From: Simon Davis
Sent: 25 March 2019 11:06
To: Planning.Responses
Subject: FW: BR/326/18/PL
Attachments: 3.901 External Materials.pdf; 3.903 Window Details.pdf; 3.902 Railing Details.pdf

The royal Hotel - BR/326/18/PL

The application is for the refurbishment of the existing building, external alterations, extensions and reconfiguration of a previously permitted conversion. The proposal is to provide an A3 restaurant and 27 flats.

TYPICAL WINDOW DETAIL

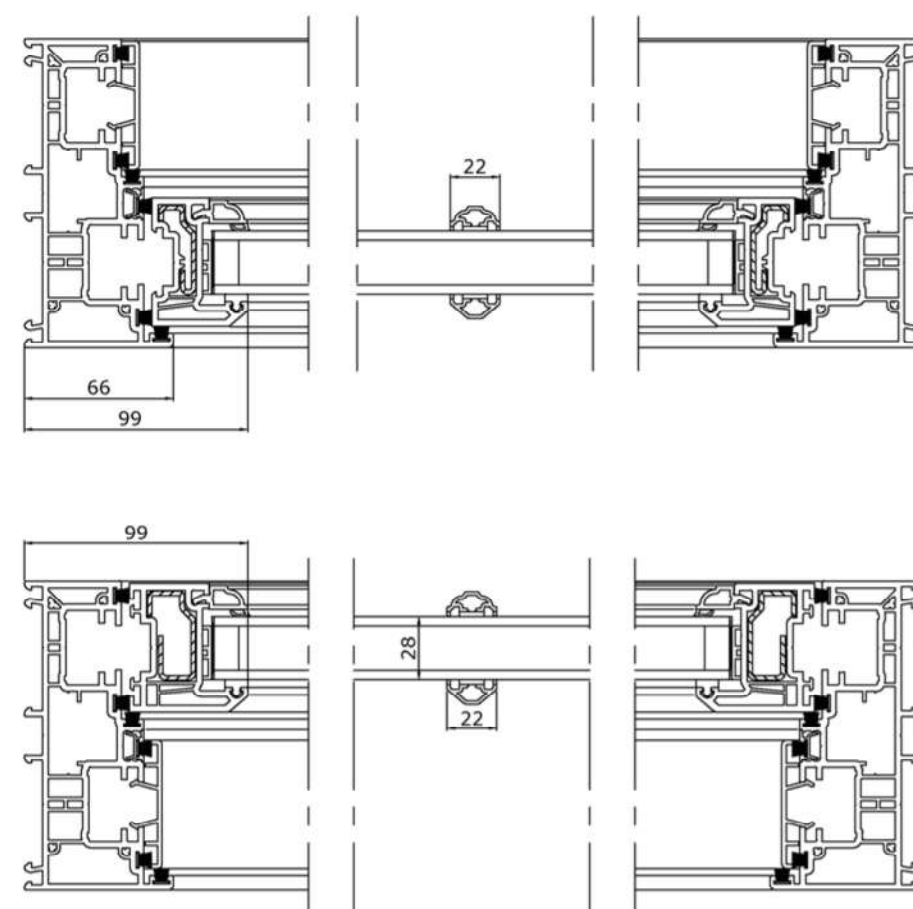
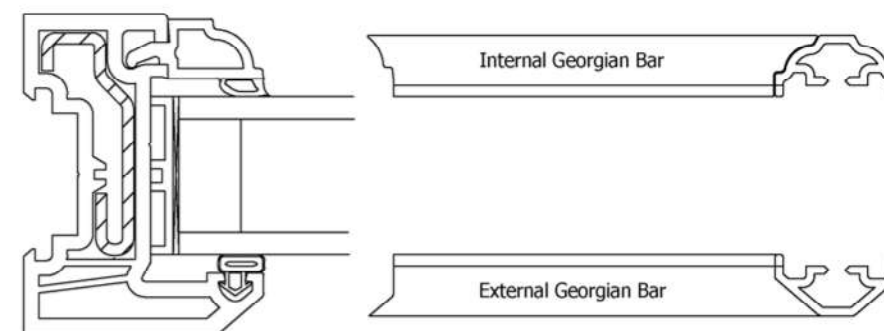
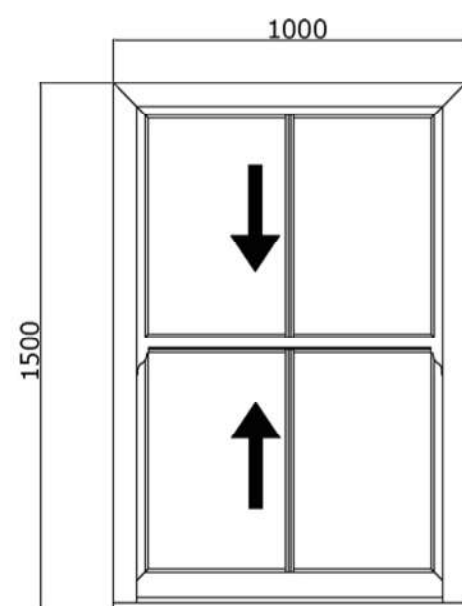
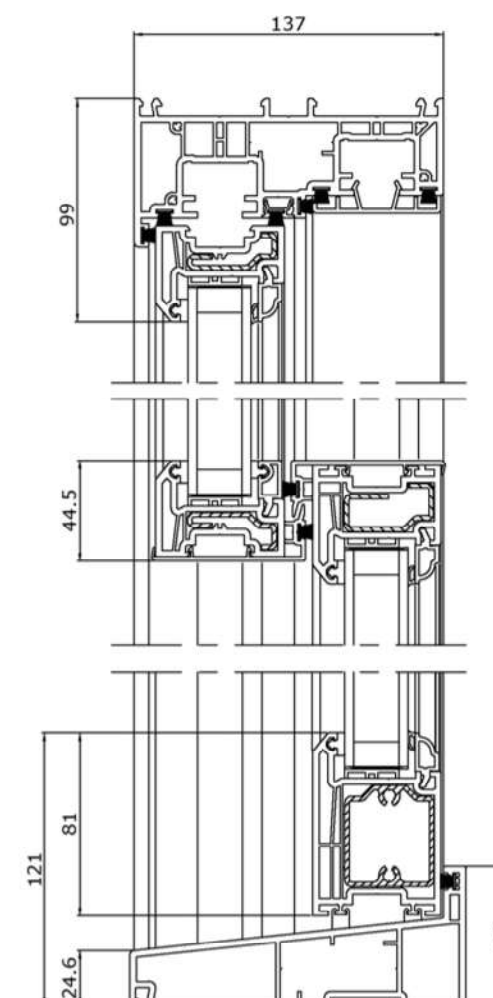
The fenestration of the building will have a significant impact upon the success of the works, and should closely reflect the remaining traditional windows. It is considered that the best approach would be to use sliding sash

windows. The windows should also be such that the design/measurements closely reflect the existing, remaining traditional windows.

It is suggested that details of all of the windows, railings and external paint colours be supplied prior to works commencing in order to ensure that they reflect the traditional character of the conservation area. .
